The Secretary
NSW Planning, Industry & Environment

10 December 2019

I refer to the Department's below email of 12 November 2019 advising of the public exhibition of State Significant Development SSD-9653 Hills Showground Station Precinct (Lots 53, 55 and 56 DP 1253217 and Part Lot 50 DP 1253217) being for the 'Concept proposal for a mixed-use precinct adjacent to the Hills Showground Station, including maximum gross floor area for residential and non-residential land uses, building envelopes, parking rates, principal subdivision and public open space'. Submissions need to be made to the Department by 10 December 2019.

Figure 2-2: Feeders in the vicinity of Carrington Road and Showground Road

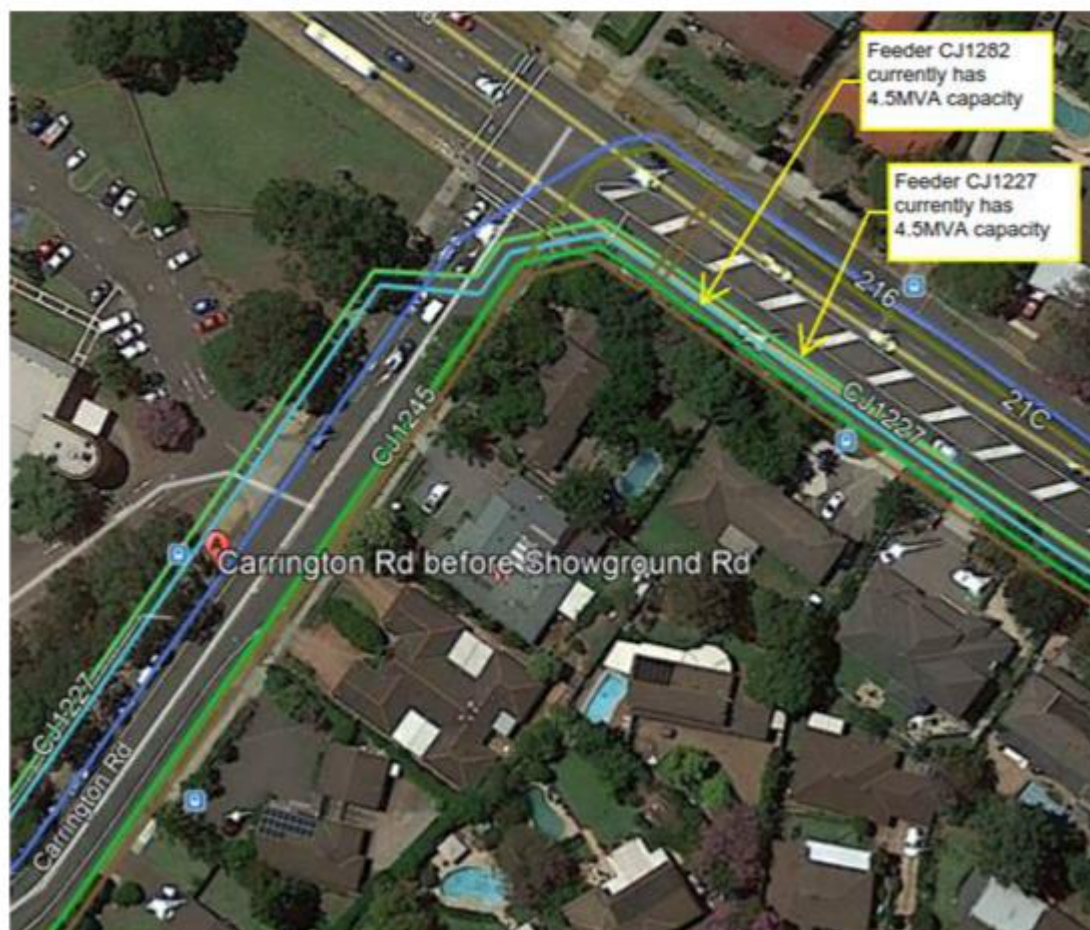
Endeavour Energy has noted the following in the Utility Servicing Impact Assessment:

A technical enquiry was submitted to Endeavour Energy on 17/06/19 requesting information on the available capacity of the existing network servicing the Precinct. Endeavour Energy's response provided information about the current electrical loading around the Precinct, including the available feeders to supply the Precinct. The available feeders along Carrington Road and Showground Road are presented in Figure 2-2

- 4 x 11kV feeders in the vicinity of the intersection of Carrington Road and Showground Road
- Feeders CJ1127 & CJ1282 each have an available capacity of 4.5MVA (represented by the green lines in Figure 2-2)
- Combined, there is a total of 9MVA capacity available between feeders CJ1127 and CJ1282.

Endeavour Energy's Asset Strategy & Planning Branch whilst not having undertaken a detailed analysis of the Development Application have provided the following advice:

Asset Strategy & Planning Branch have no additional comments or concerns regarding the proposal.
